RESPONSE TO SUBMISSIONS

ATLASSIAN CENTRAL
8-10 LEE STREET, HAYMARKET

PREPARED FOR
VERTICAL FIRST PTY LTD
JUNE 2021

FIGURE 1 - CROWN AXONOMETRIC

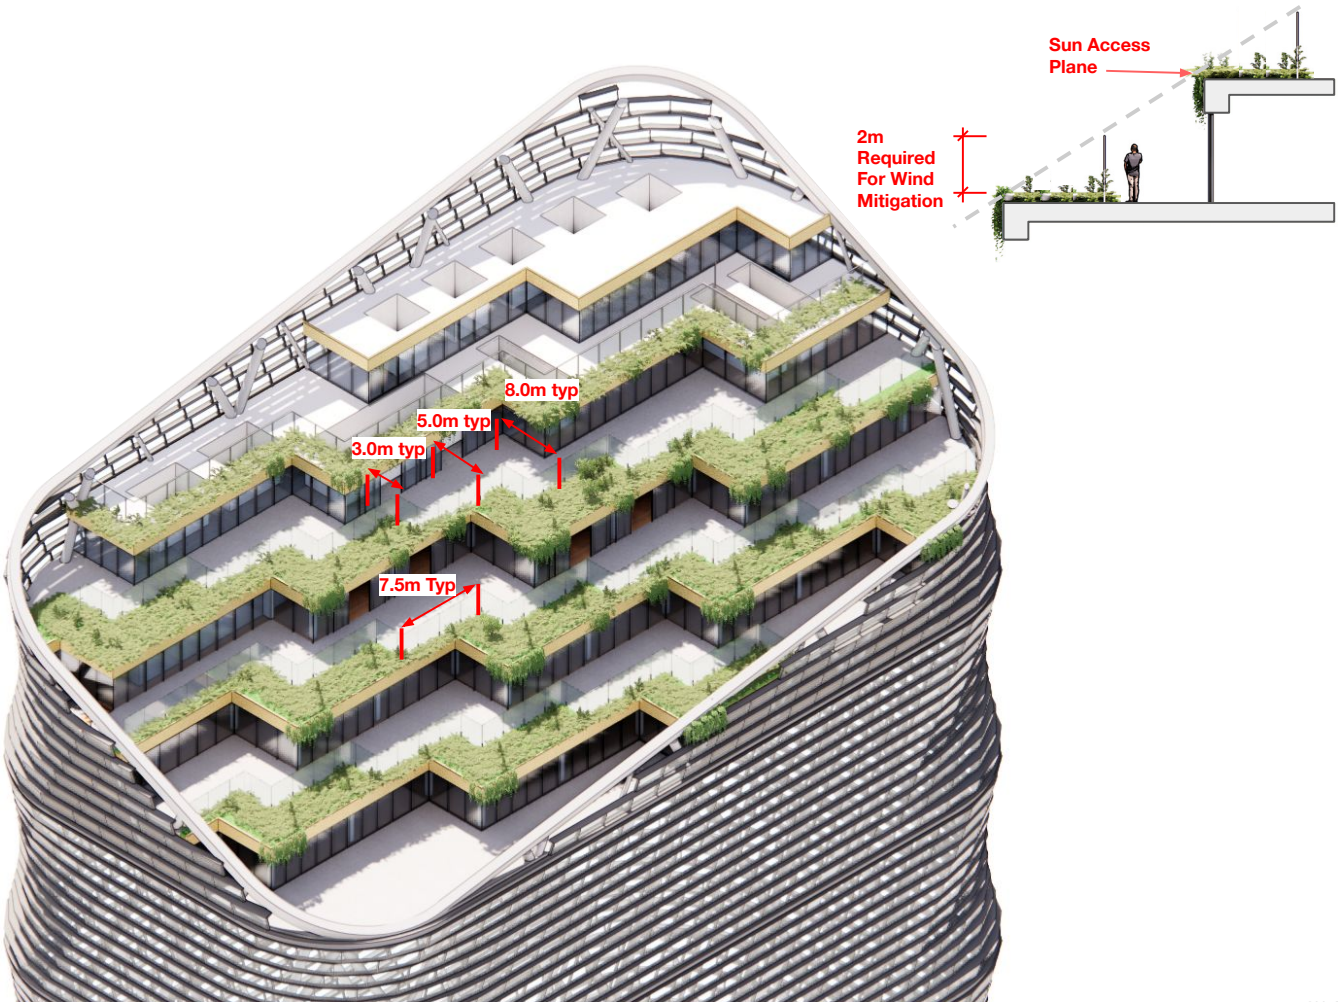
The proposal overshadows Prince Alfred Park by way of high glass balustrading to the roof terraces and thereby exceed the applicable sun access plane. This is avoidable and can be fixed.

FIGURE 1 - PLATFORM 1 ELEVATION - PREVIOUS PROPOSAL

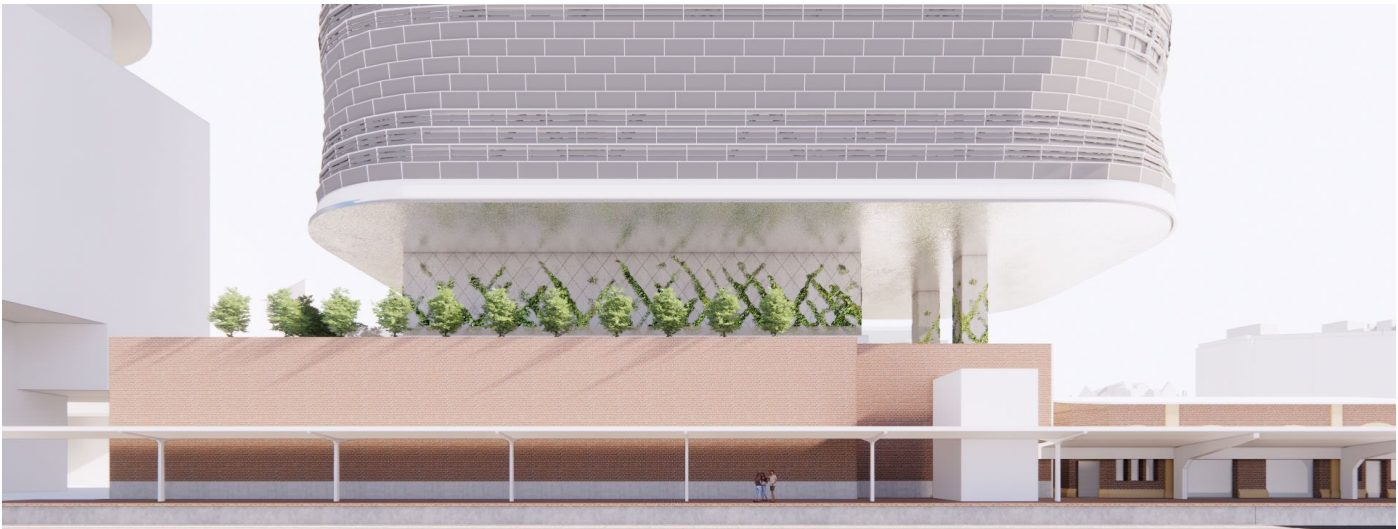
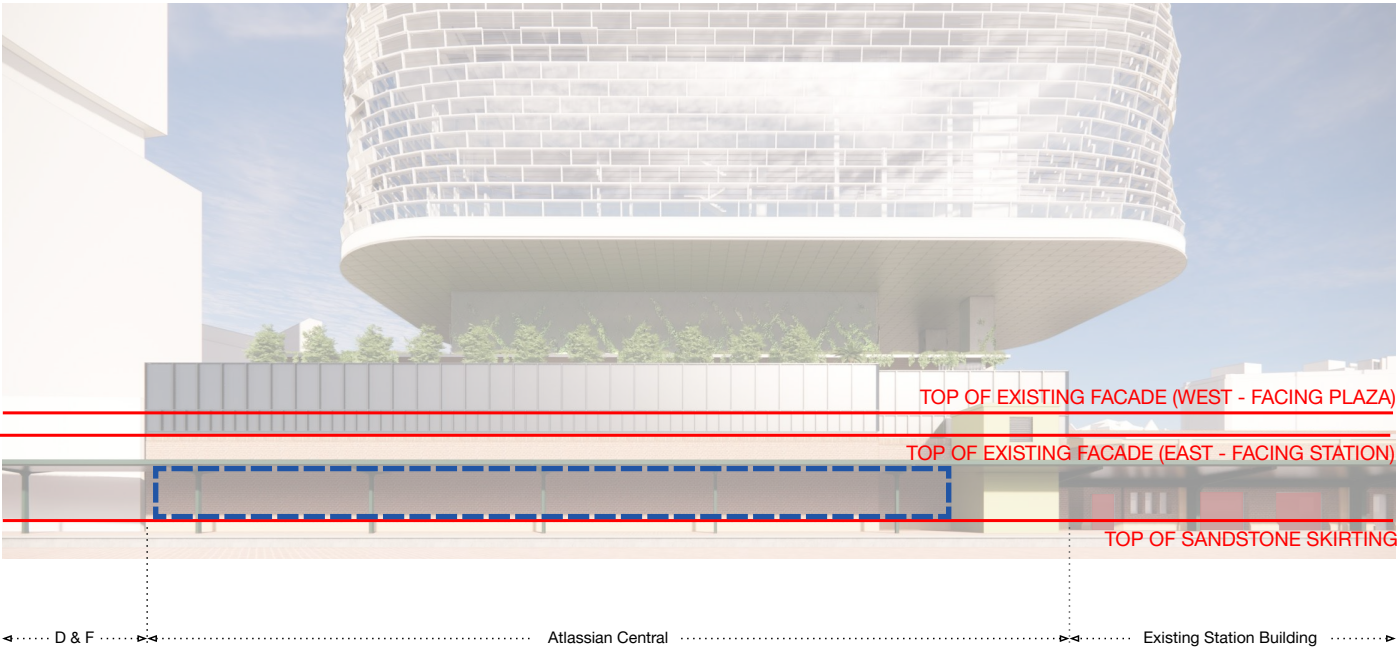
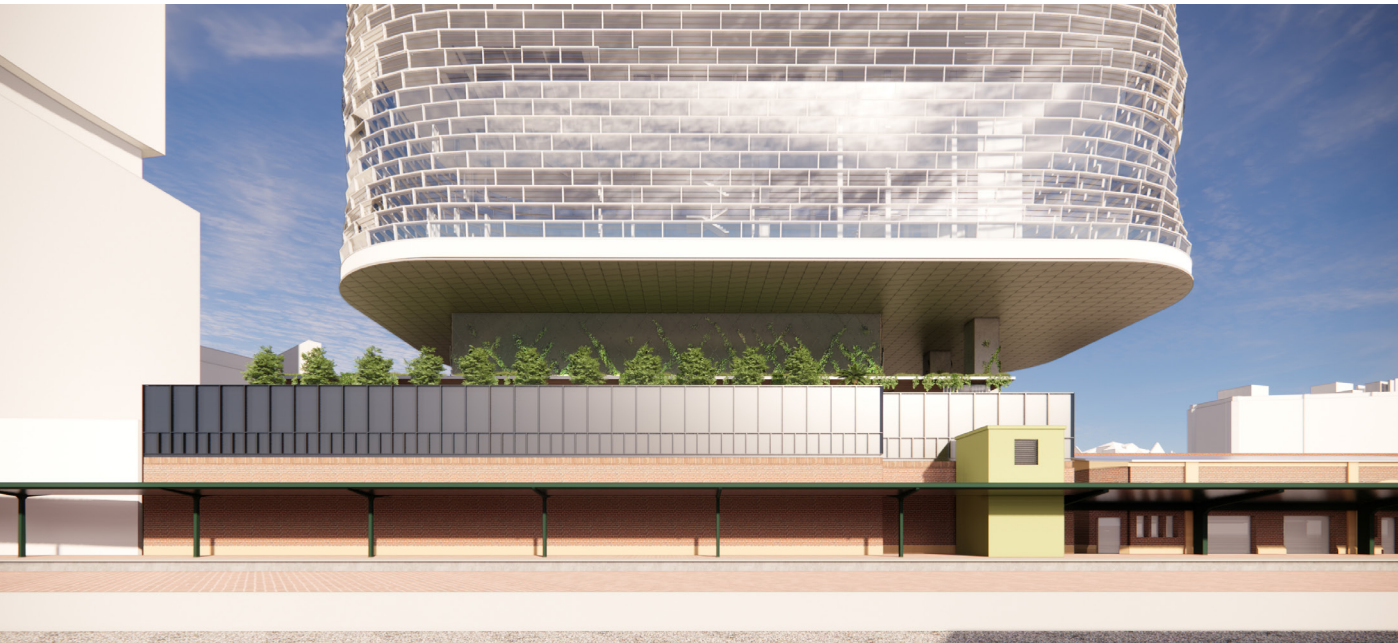
- The blank wall on the ground floor on the eastern elevation separating the train station does not deliver any connectivity or engagement between the new development and the station.

FIGURE 1 - INDICATIVE TECHNICAL SECTION - LEVEL 15

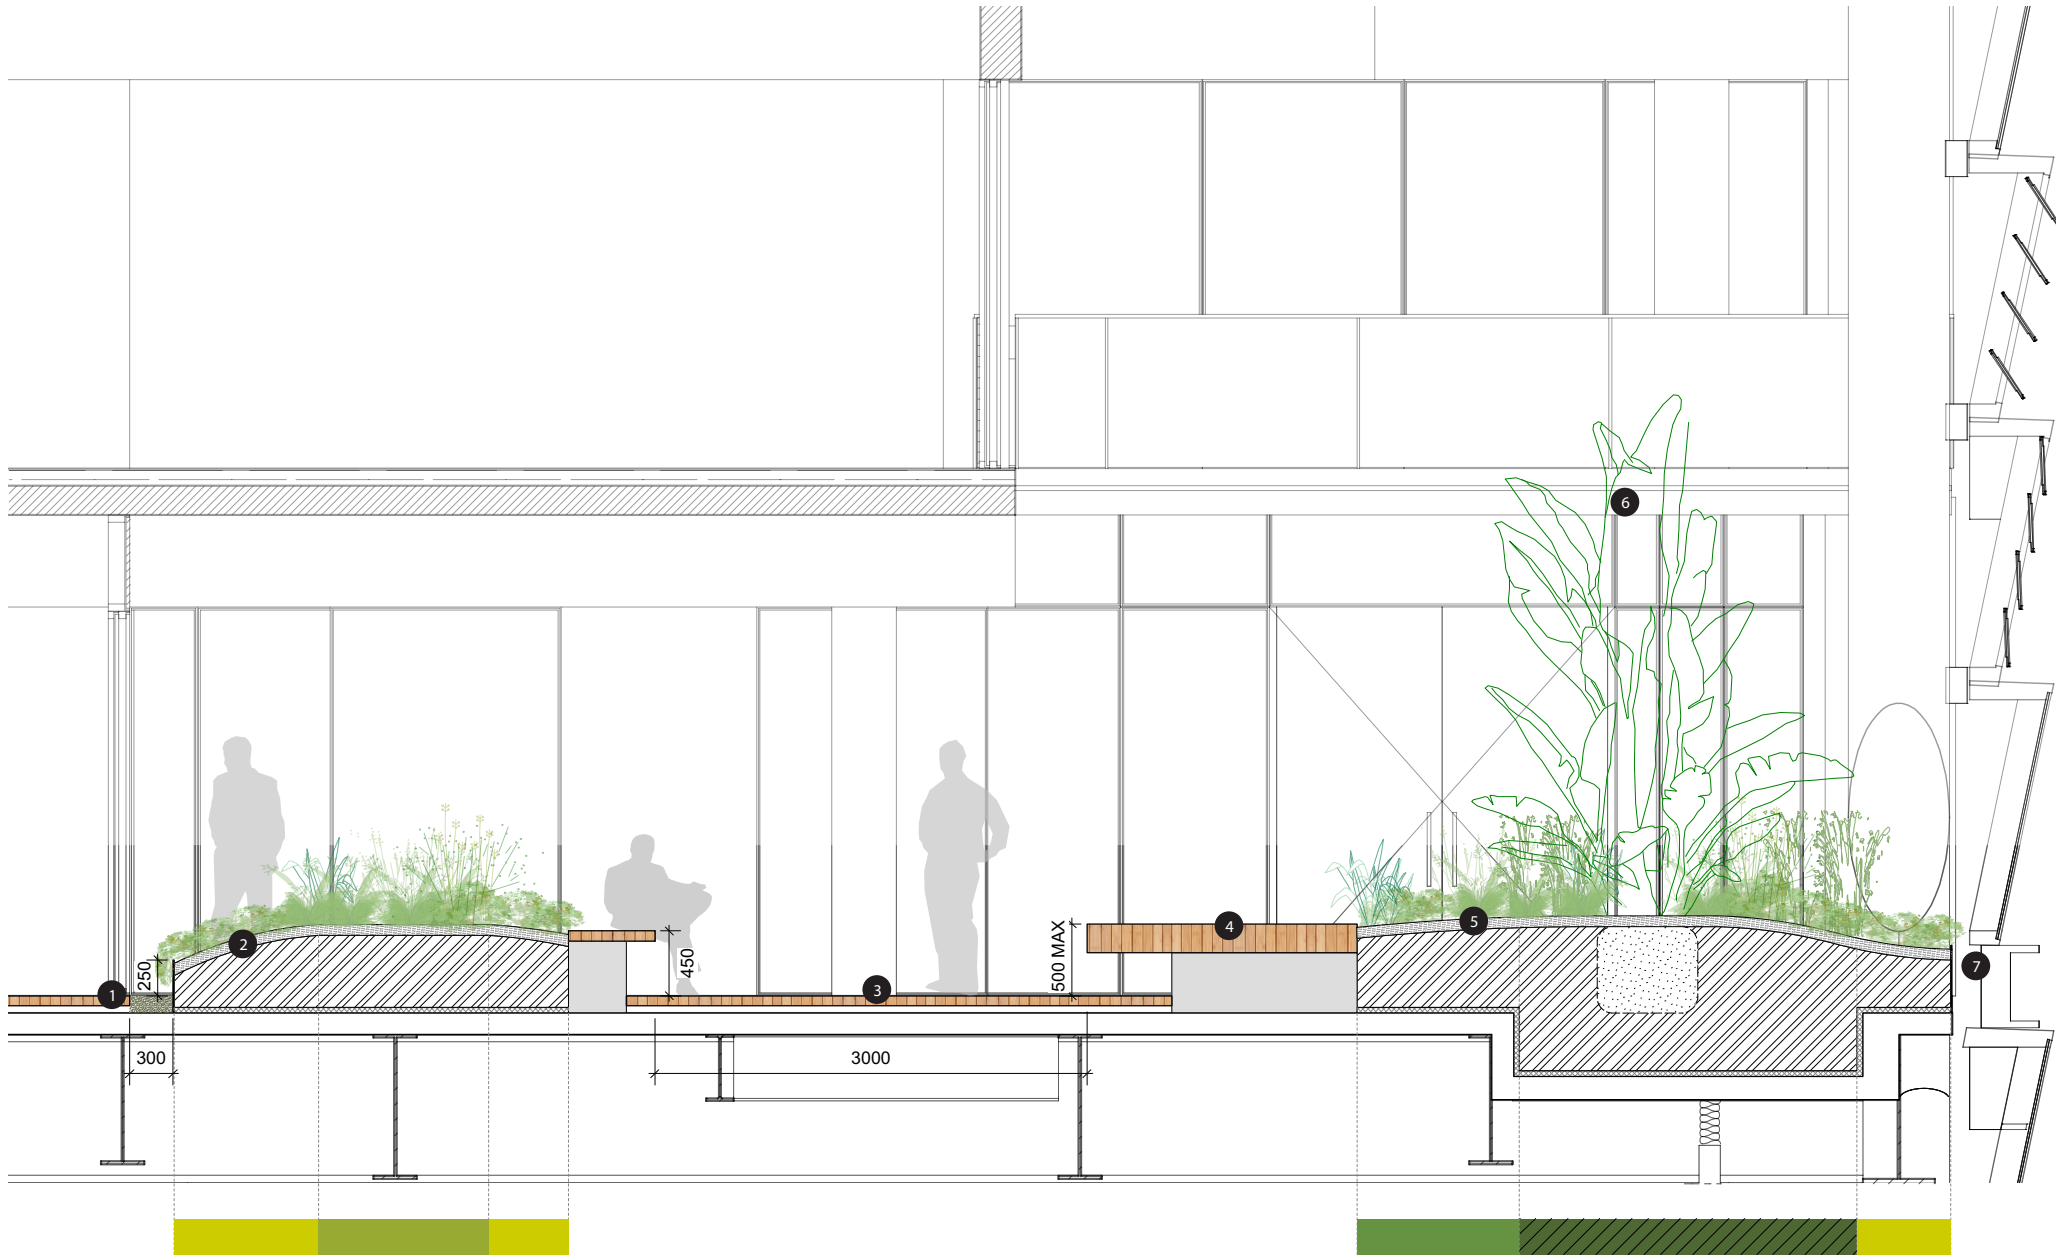
- Review the design of all planters, and freestanding pots in the public domain and tower, to ensure landscape areas on slab achieve the minimum soil depths and soil volumes in accordance with the Sydney Landscape Code Volume 2.
- Provide updated plans with levels (SSL, RL, TW), typical details and confirm the soil volume for all new trees.
- Ensure that any landscape conditions reference the Landscape Code Volume 2.
